From: Mark Kingston [REDACTED]
Sent: 14 November 2017 19:16
To: Planning.Responses
Subject: Re: Representation on: FP/259/17/HH at 22 North Way

PROPOSED PLANS

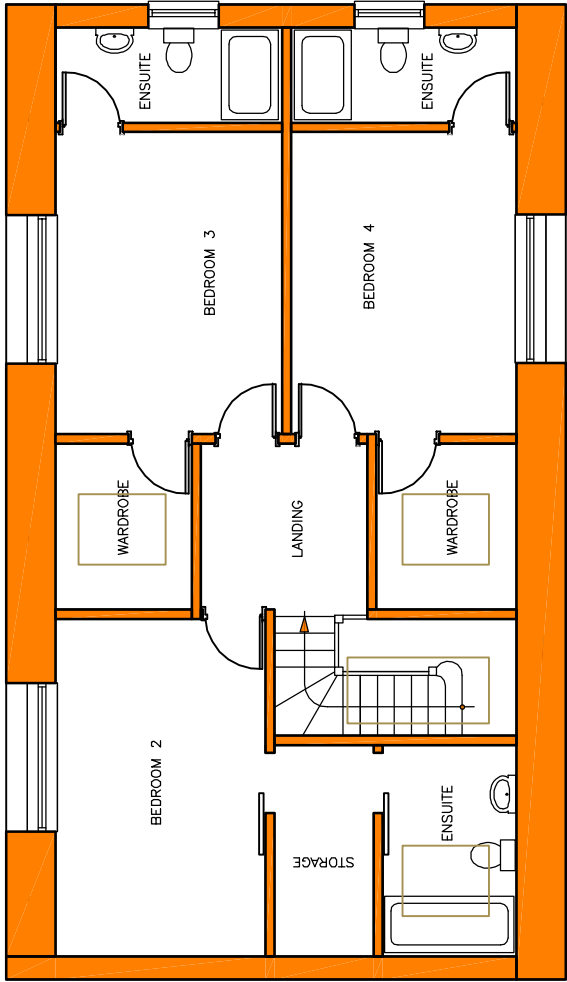
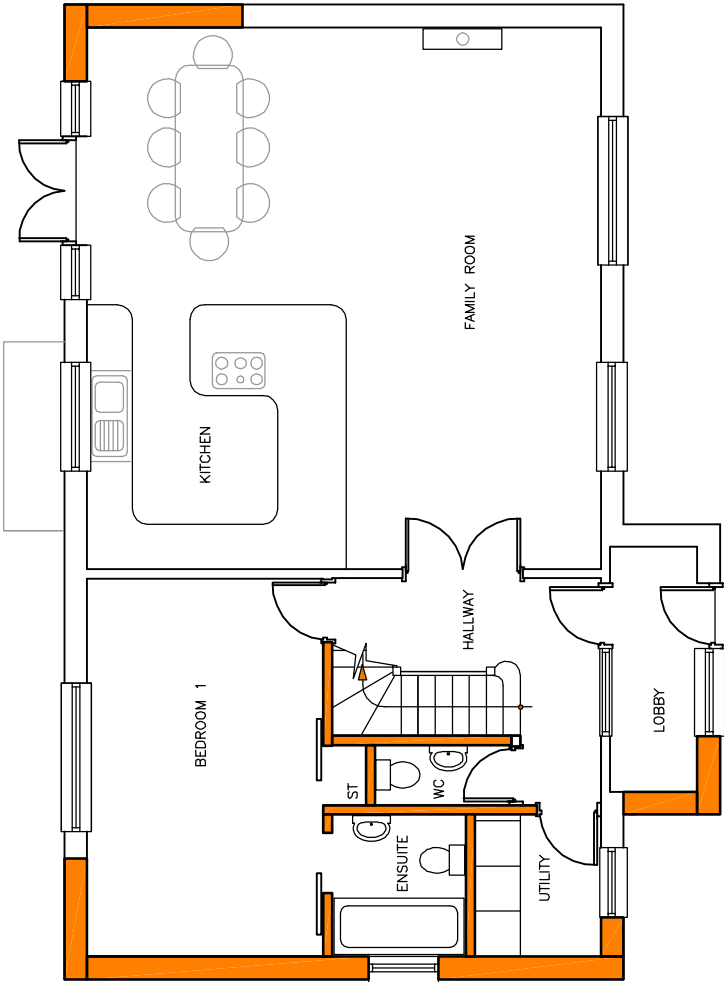
Having just read the application again I would like to make following additional comment in that the application states that it will not effect the current parking arrangement.
This is in fact incorrect as it clearly does away with the current garage.
It is also incorrect as it does not allow for the increased parking going to be required due to the increase in bedrooms.
As the size of the plot does not allow for off road parking I would hope the plans are turned down.
Please add this to my previous objection.
Regards
Mark Kingston
